Mortham Estates
A66 NTP Proposal
Development Consent Order Application by National Highways
Deadline 5 Post Hearing Note
To
Planning Inspectorate
IP Ref No 20032137.

1.1 This Post Hearing Note (PHN) has been prepared following the Item Specific Hearing held on Thursday 2nd March 2023 which, inter alia, considered the Applicants justification for the compulsory acquisition and woodland planting of Mitigation Plot 08-01-16

Drawing Title
**Land Plans
Regulation 5(2)(i)
Sheet 2 of 3**

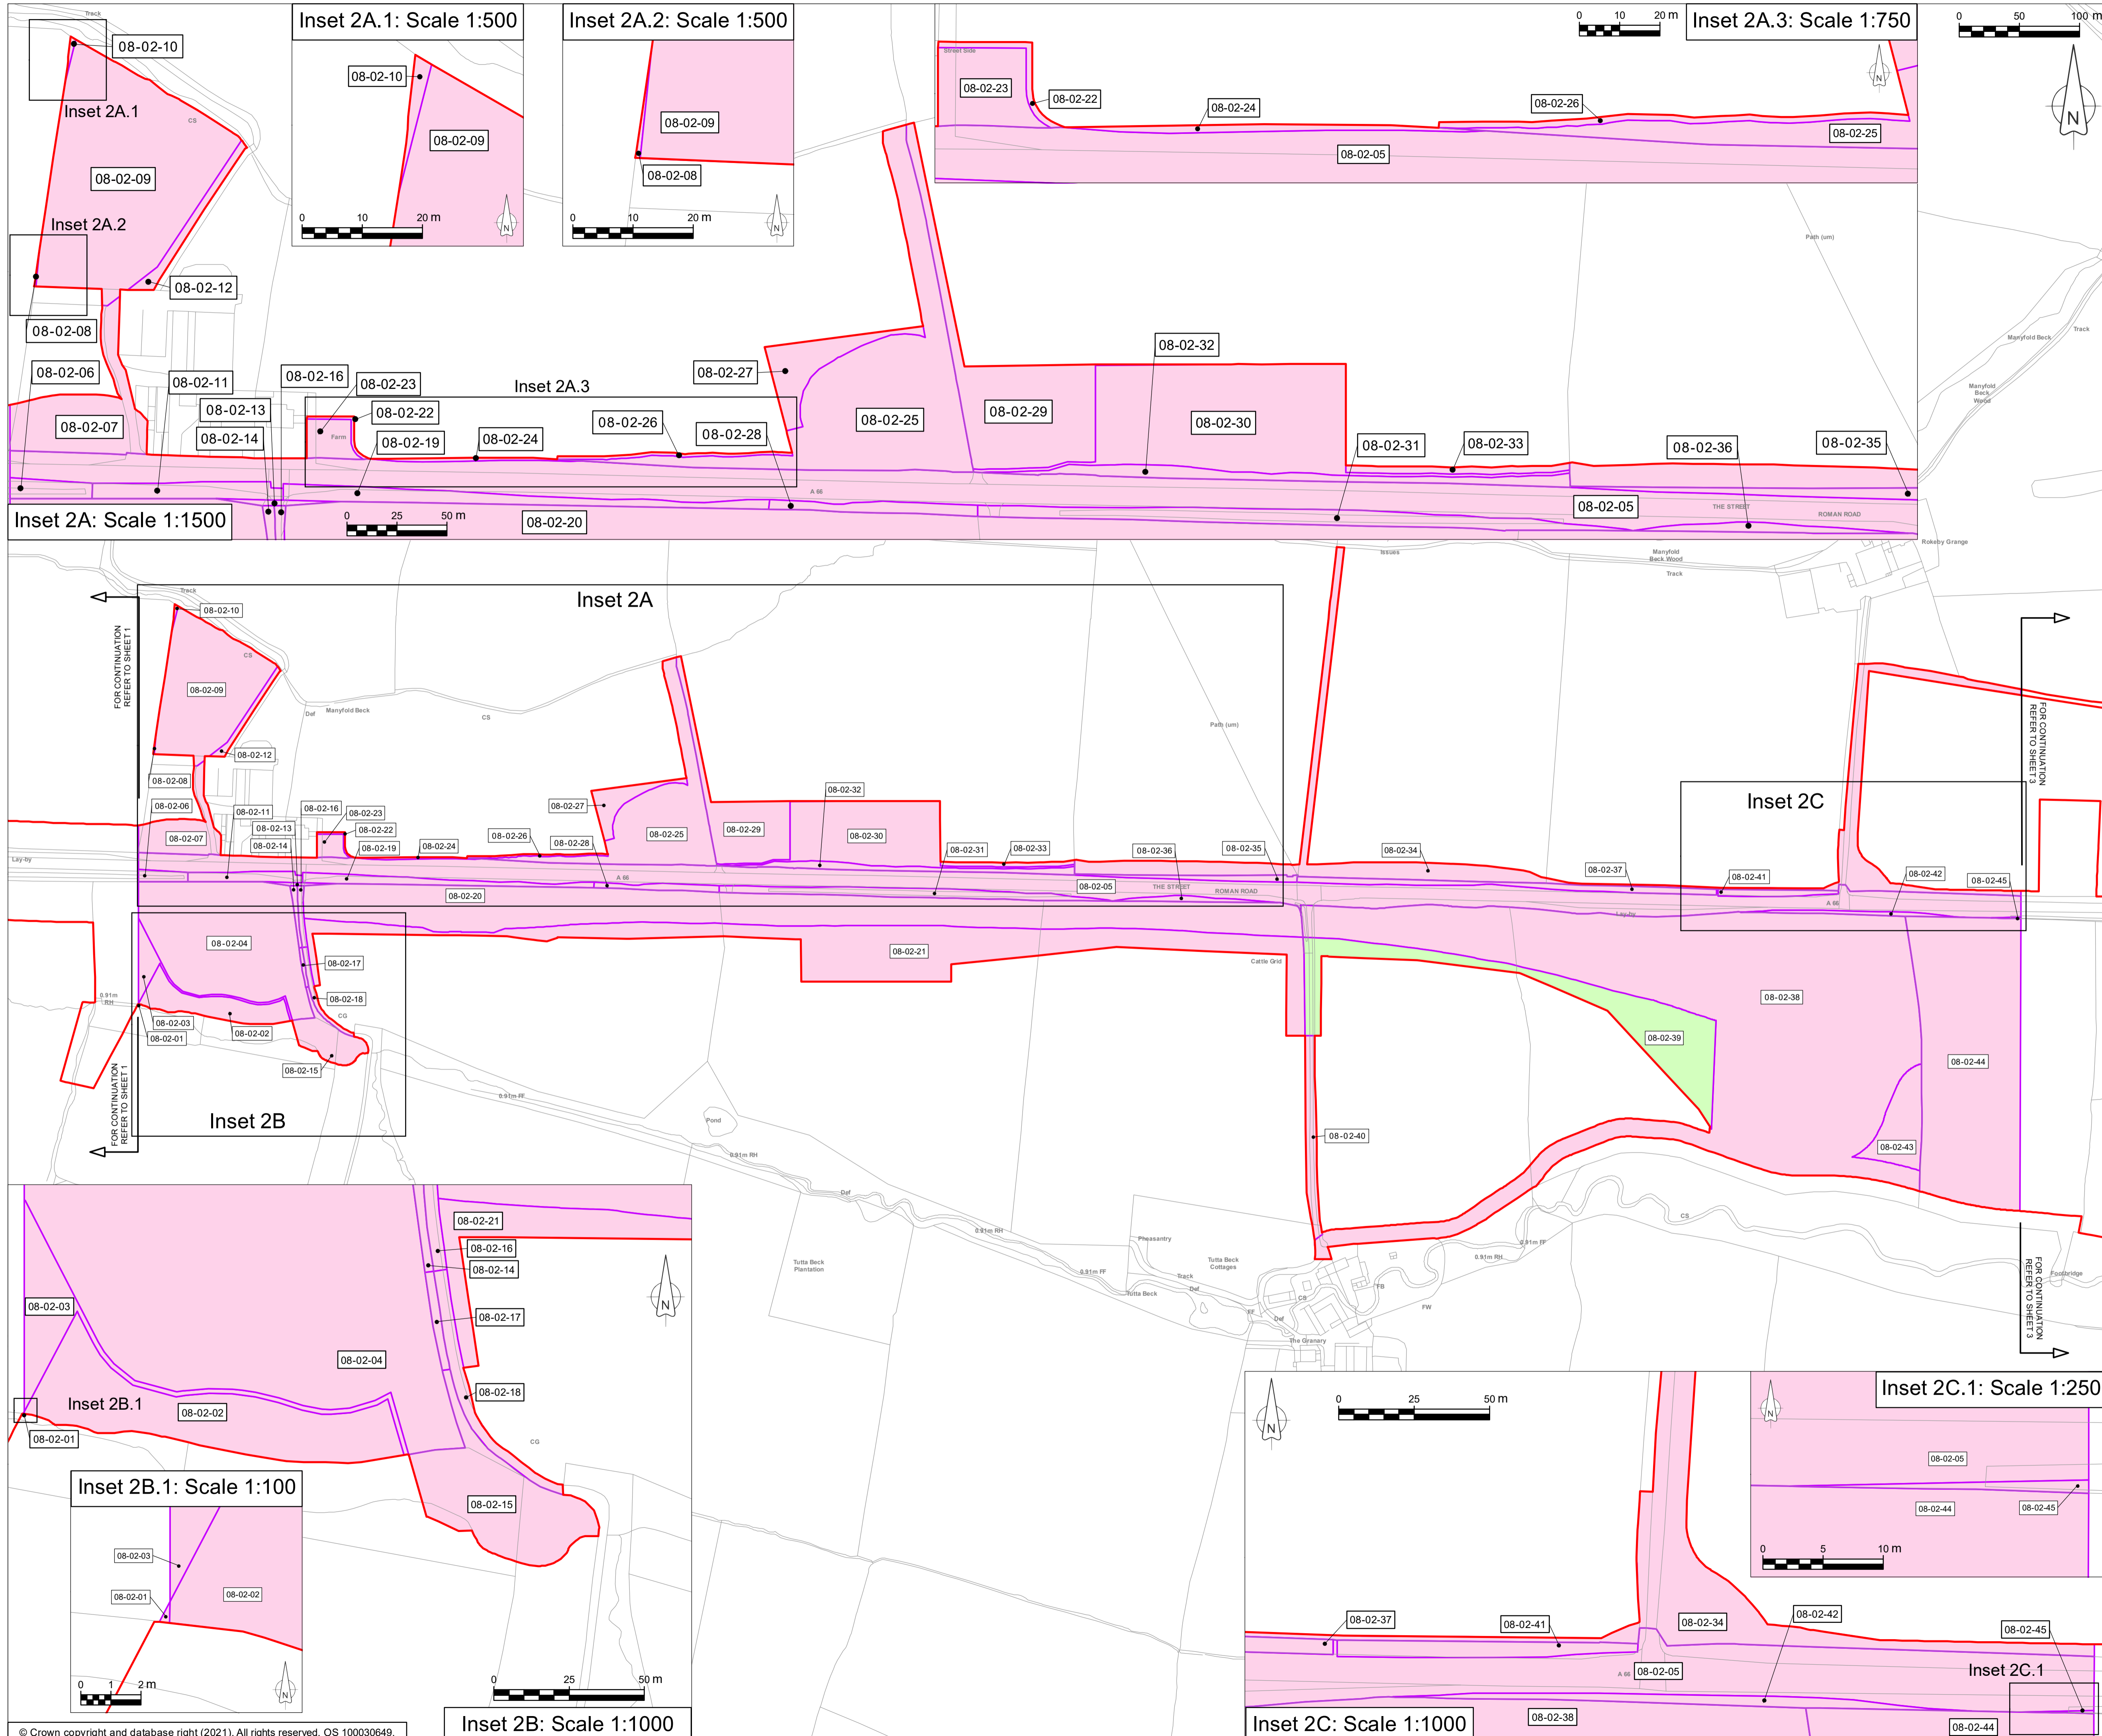
- 3.1 The historic character and appearance of the Mortham Estate along the A66 corridor – particularly the impact of Mitigation Plot 08-03-01 on the setting of St Mary's Church at Rokeby and the avenue of pollarded large leaf limes along the western boundary of the churchyard (views into and out)
- 3.2 The Estates' 10 year Woodland Plan (map attached)
- 3.3 The loss of productive agricultural land and the impact upon the respective farm businesses
- 3.4 The adverse impact of the proposal upon the pheasant shooting and deer stalking/control conducted by the Estate
- 3.5 The sterilisation of the identified mineral reserves identified by Breedon Aggregates (submission to DCC Minerals Plan "Call for Sites" attached)

- 5.1.1 The Applicant seeks to permanently acquire 113 acres but is not seeking any areas to hold on "temporary" or "essential" licence. This includes the permanent acquisition of component parts of the Rokeby Registered Park and Garden (RPG) (Plots 08-03-08 & 08-03-17). No explanation has been given nor assessment made of the impact of this proposal on the designated assets
- 5.1.2 The Applicant should identify those areas where only temporary possession is required (such as for services, drainage, access,

5.3.1 The Applicant proposes a footway and cycle path (Parcel 08-03-01) to pass to the south of Rokeby Grove and Tack Room Cottage to replace the existing provision to the north, running alongside the A66 westbound carriageway within the Greta Bridge by pass cutting

5.3.2 No assessment has been made of the impact of this proposal – which was made after the assessment of the scheme was undertaken

- 4.1 Notwithstanding that we cannot identify the woodland loss of 2.58ha in Scheme 8 nor the 4.5ha in Scheme 7 and our belief that if such loss has occurred mitigation should follow the Applicants criteria by locating this within the Scheme concerned (as woodland within Scheme 7 is rarer and of more landscape and environmental value than that in Scheme 8), we offer a site at the entrance of Cockleberry Farm to the south of the Cross Lanes junction amounting to 6.70 ha (compared to the 6.73ha sought)
